THE MEMBER-SECRETARY,  
Chennai Metropolitan  
Development Authority,  
No. 8, Gandhi-Irwin Road,  
Chennai-600 008.

Letter No. B3/152883/97

Dated: 28-8-97

Sub: CMDA - APU - PF - Proposed construction of G+2F shops cum residential building at door no. 73, Choolai High Road, in R.S.M. 10/11 of Choolai, Chennai-112 - Remittance of DC and other charges - Reg - Reg.

SITE PLAN  
(SCALE 1:200)

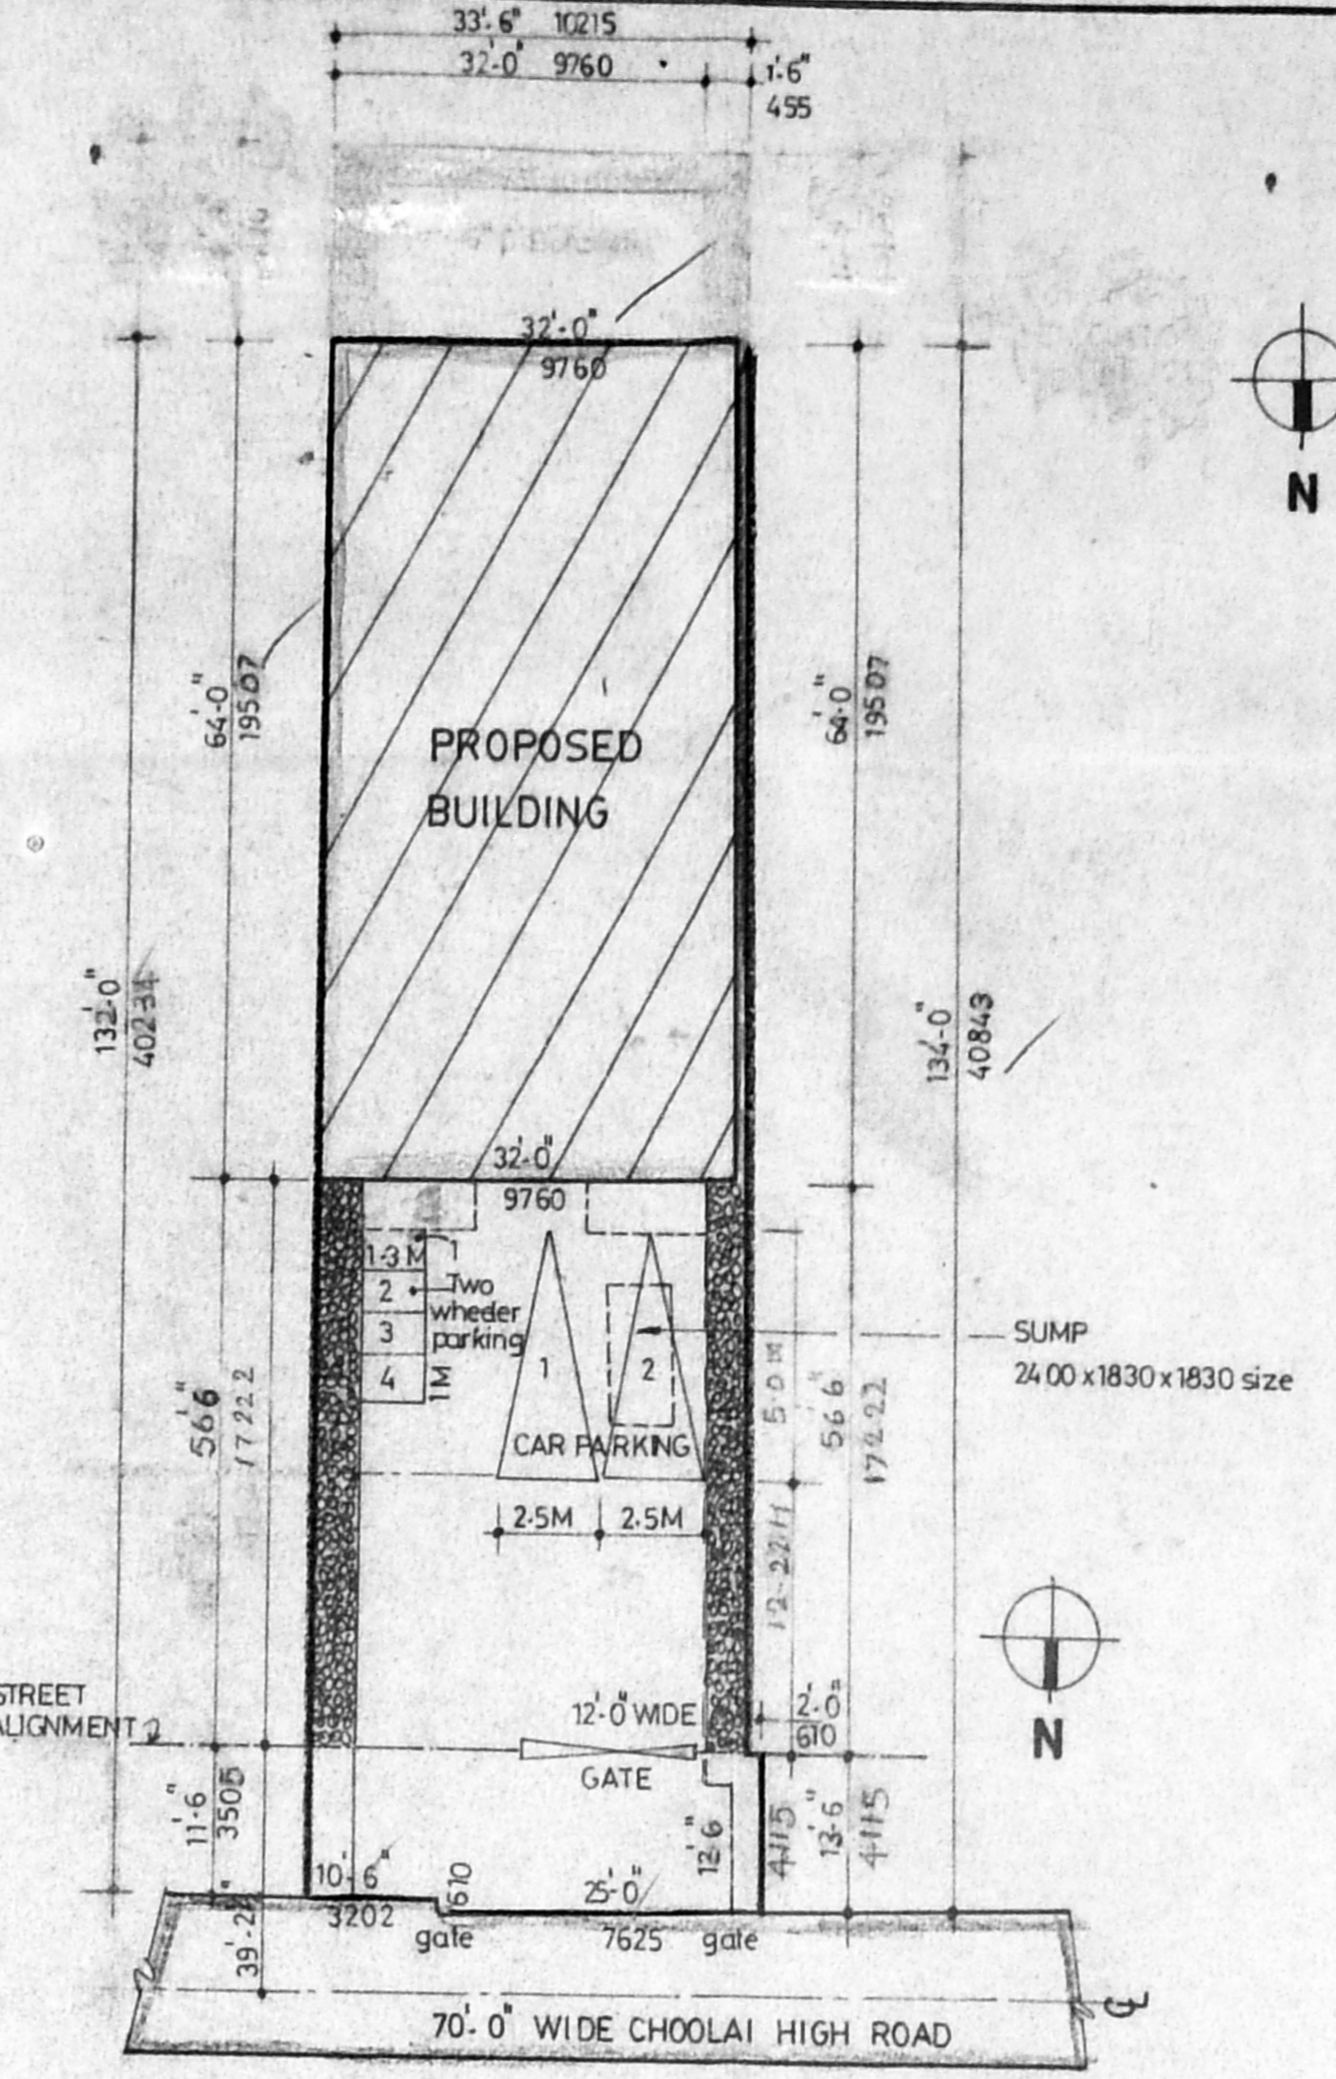
c) You are requested to furnish R.P. <sup>the</sup> rectifying the following ~~details~~ -

(i) Building line to be marked.

(ii) Parking arrangements to be indicated on the site.

(iii) Width of the road proposed gate to provided street alignment line

(iv) Balcony projection to be shown in site plan -

Gate to be indicated

EXISTING BUILDING TO BE DEMOLISHED

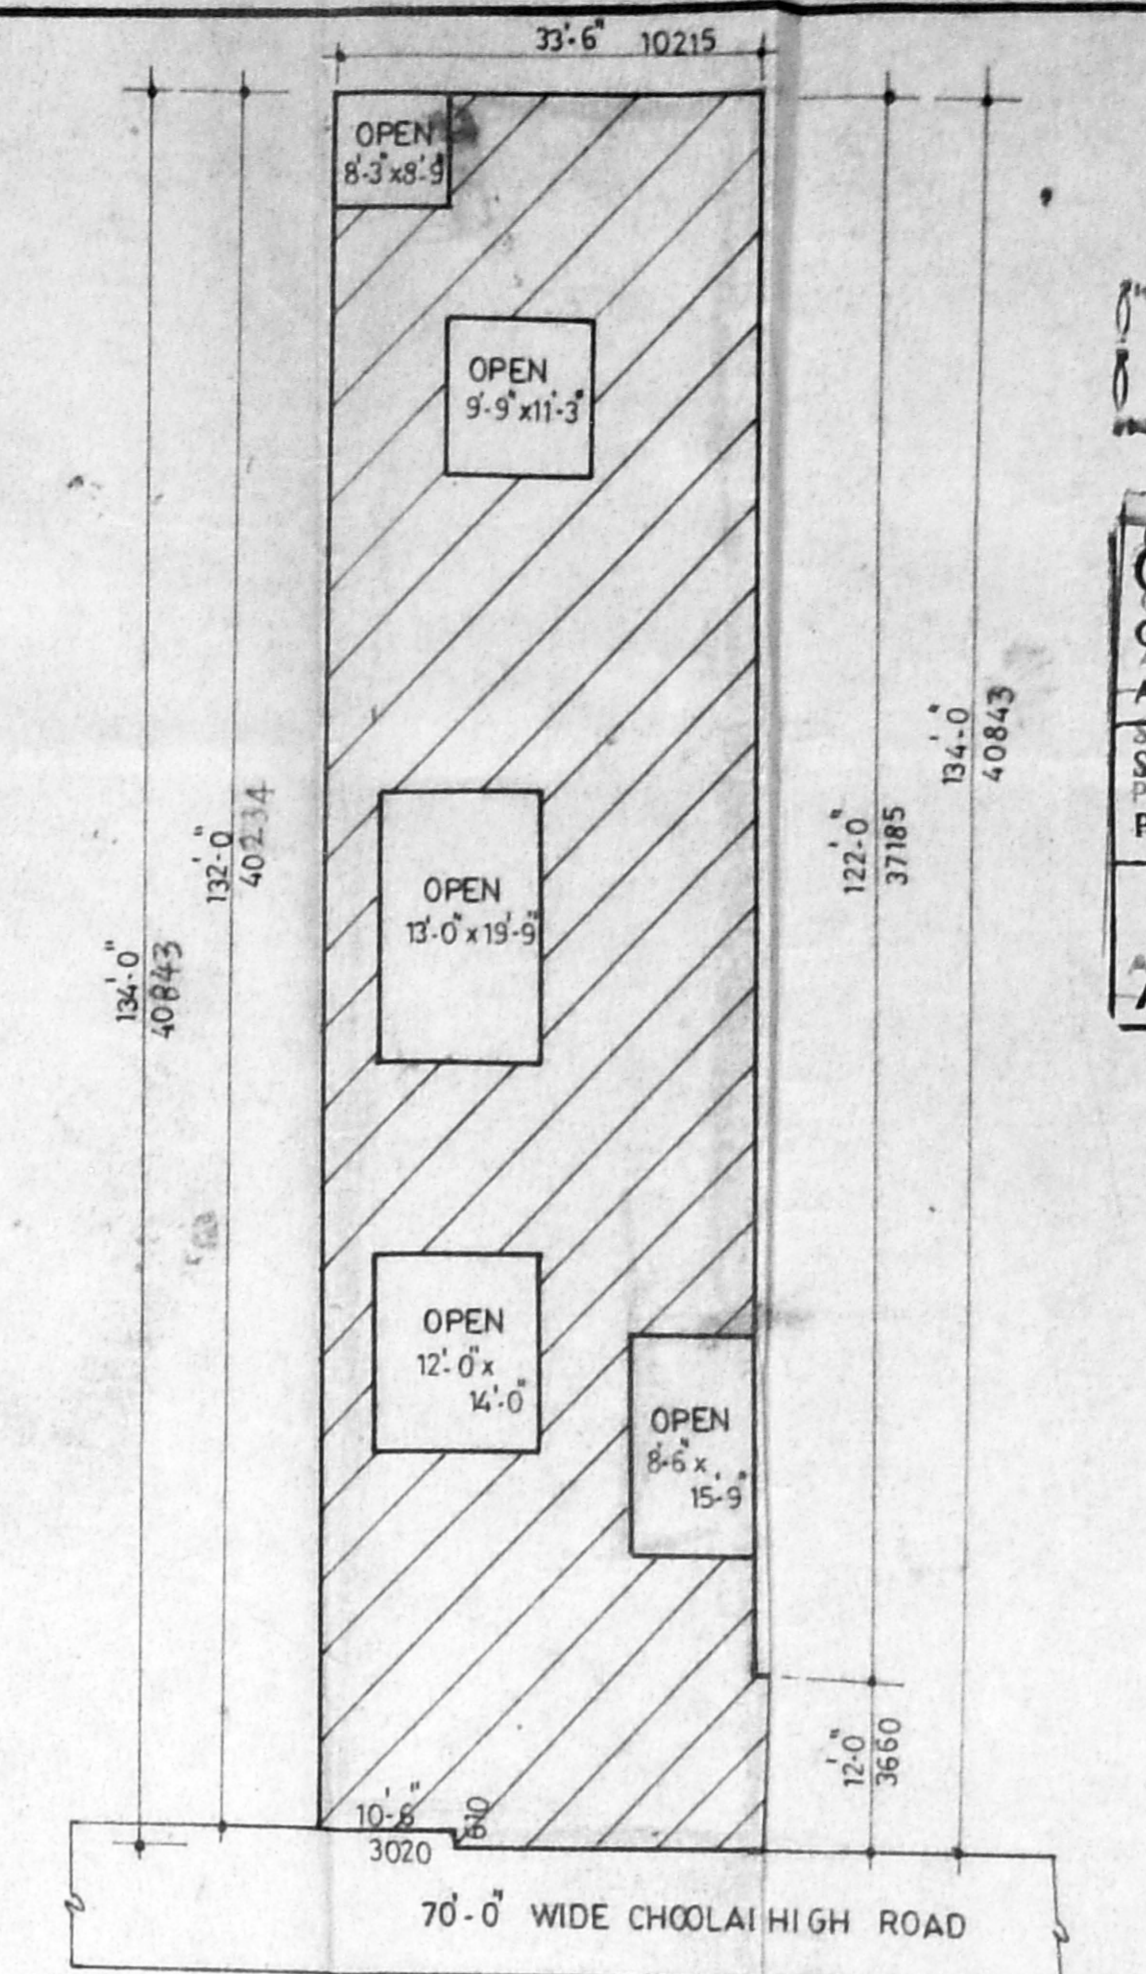
d) To furnish original copy of the Commr. Corporation of Chennai ~~Chairman's approved~~ demolition plan appd by
